Re: Planning Application 19/0471

Address: Blue Bell Farm Higher Road Longridge PR3 2YX

Description: Proposed conversion of laboratory and office to live work unit

Site Proposed
1 : 200

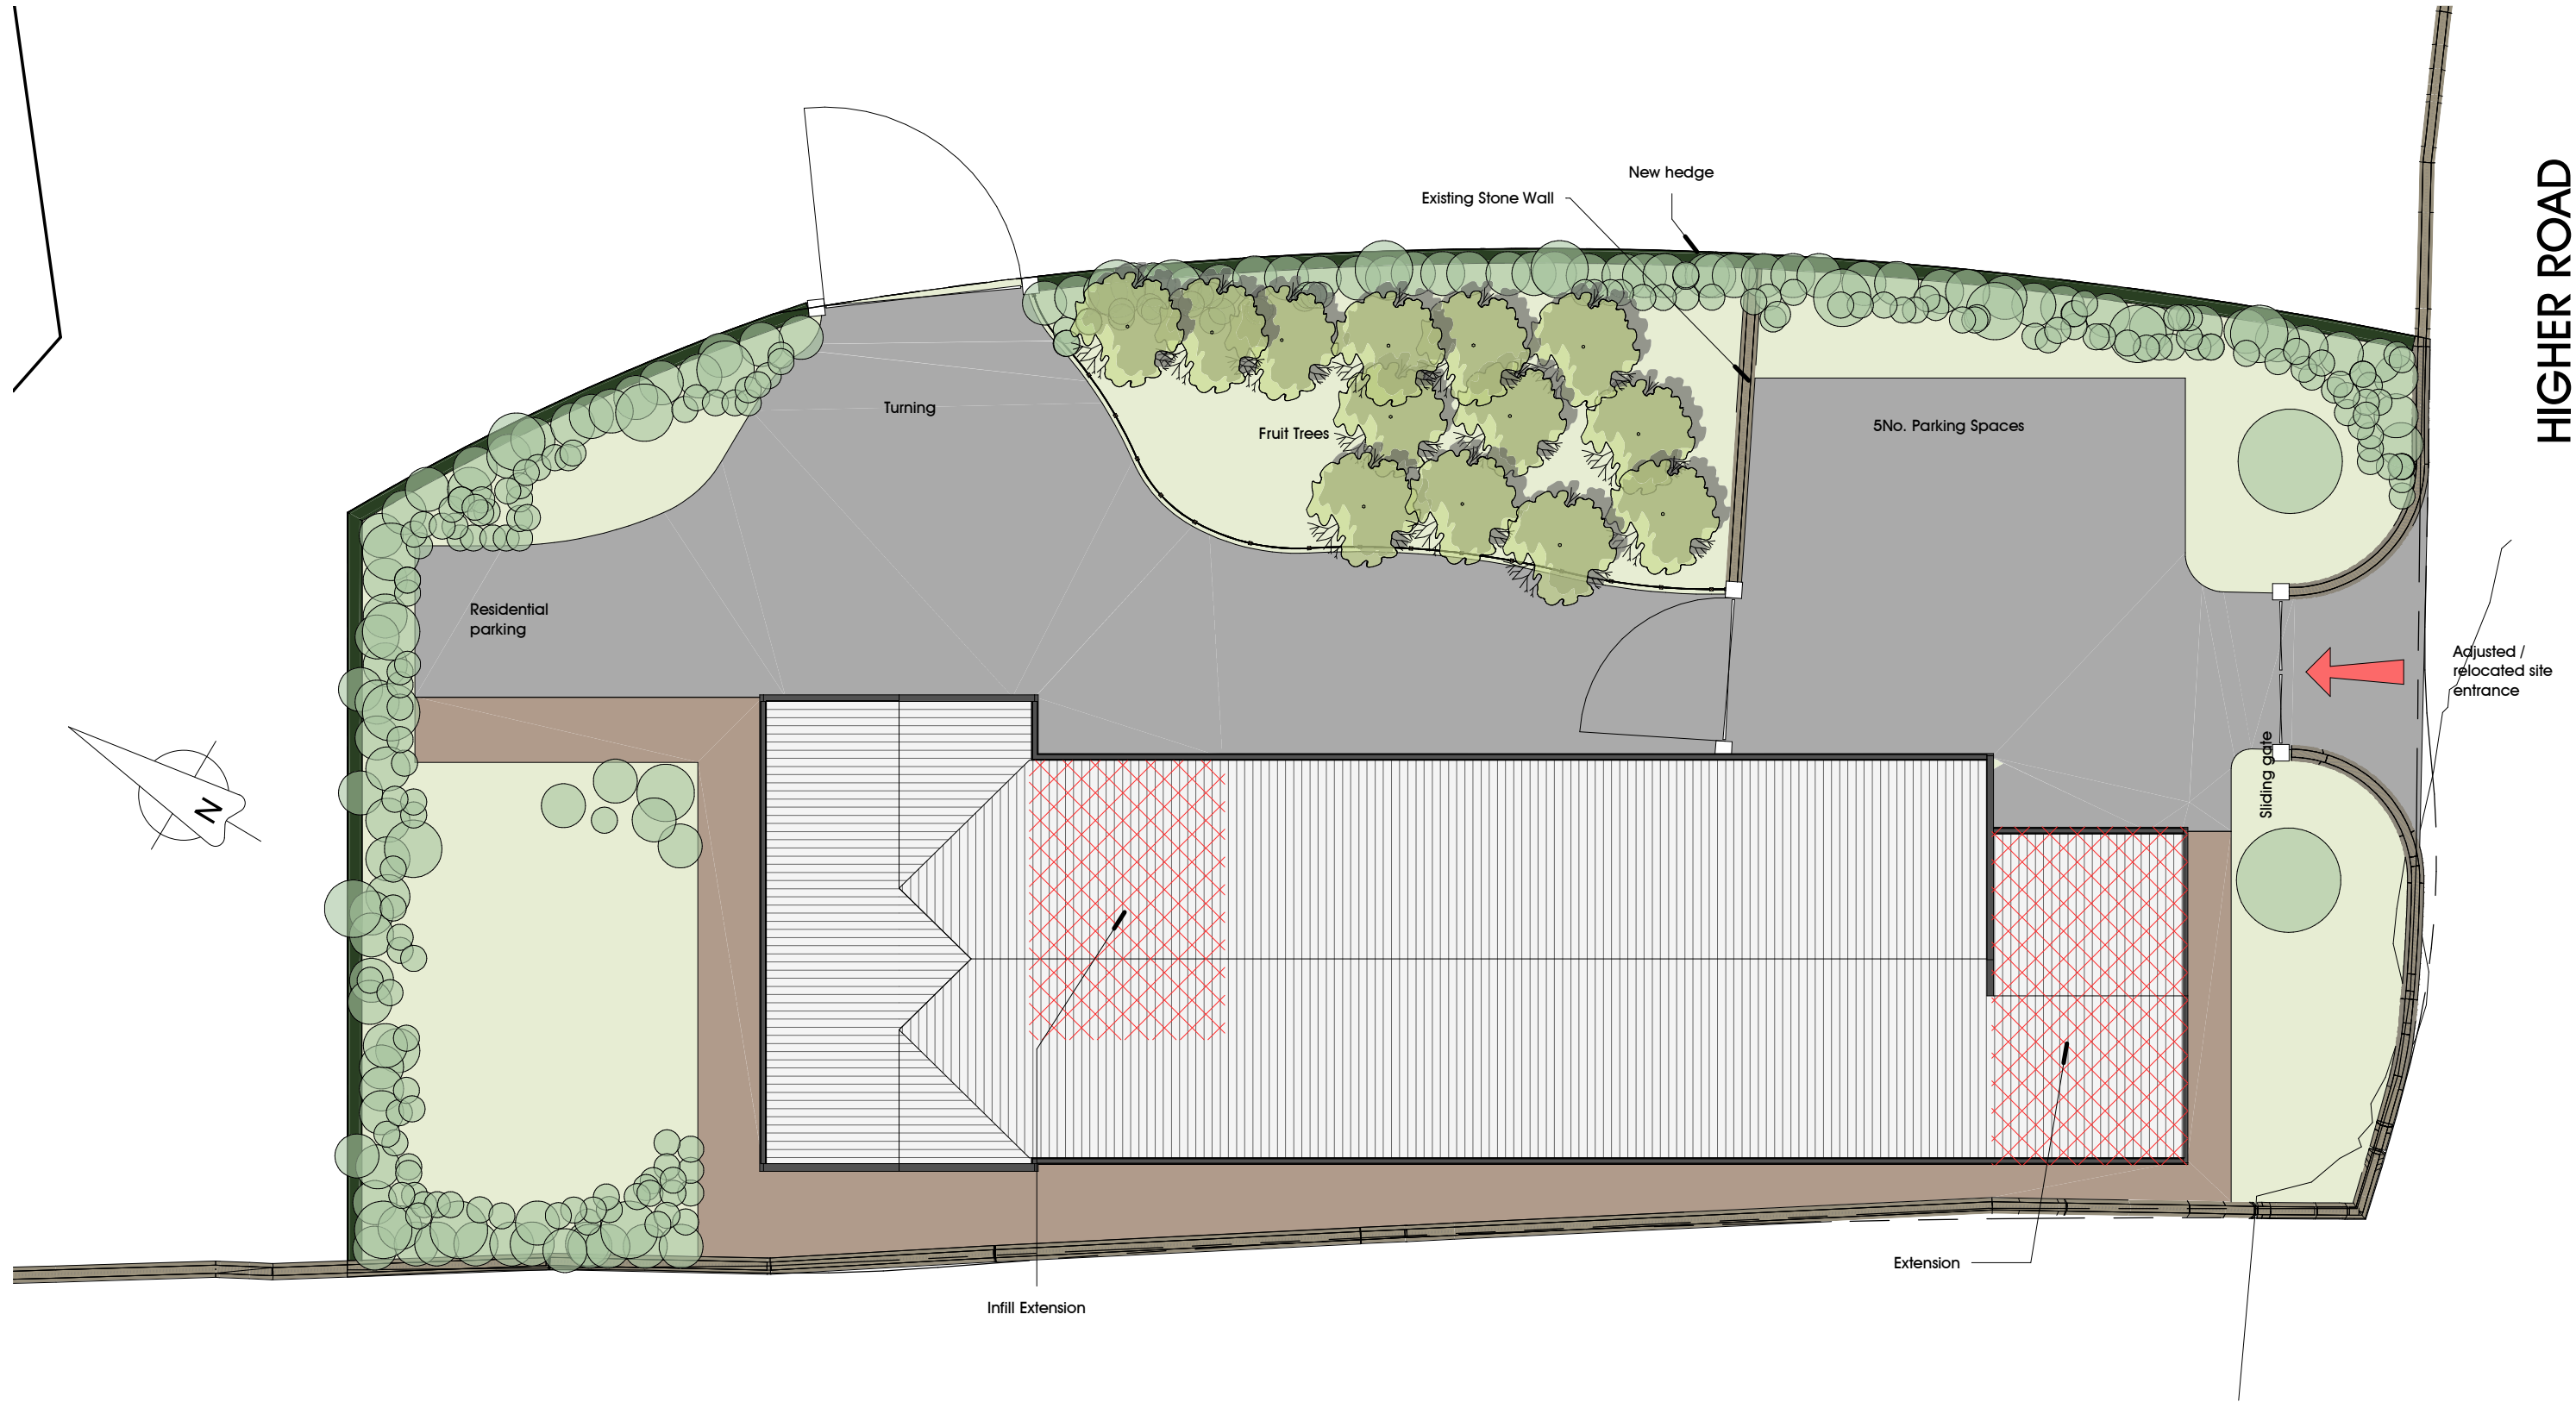
In order to progress the application we would wish for a plan to be provided showing a visibility splay of 2.4m x 140m in either direction.

1. Before the access is used for vehicular purposes, any gateposts erected at the access shall be positioned 5m behind the nearside edge of the carriageway and visibility splay fences or walls shall be erected from the gateposts to the existing highway boundary, such splays shall be 45° to the centre line of the access. The gates shall open away from the highway. **Reasons:** To permit vehicles to pull clear of the carriageway when entering the site and to assist visibility.
2. The visibility splays will require walls, fences, trees, hedges, shrubs, ground growth, structures etc. to have a maximum height of 1.0m above the height at the centre line of the adjacent carriageway.
3. Before the access is used for vehicular purposes, that part of the access extending from the highway boundary for a minimum distance of 5m into the site

shall be appropriately paved in tarmacadam, concrete, block pavements, or other approved materials. **Reasons:** To prevent loose surface material from being carried on to the public highway thus causing a potential source of danger to other road users.
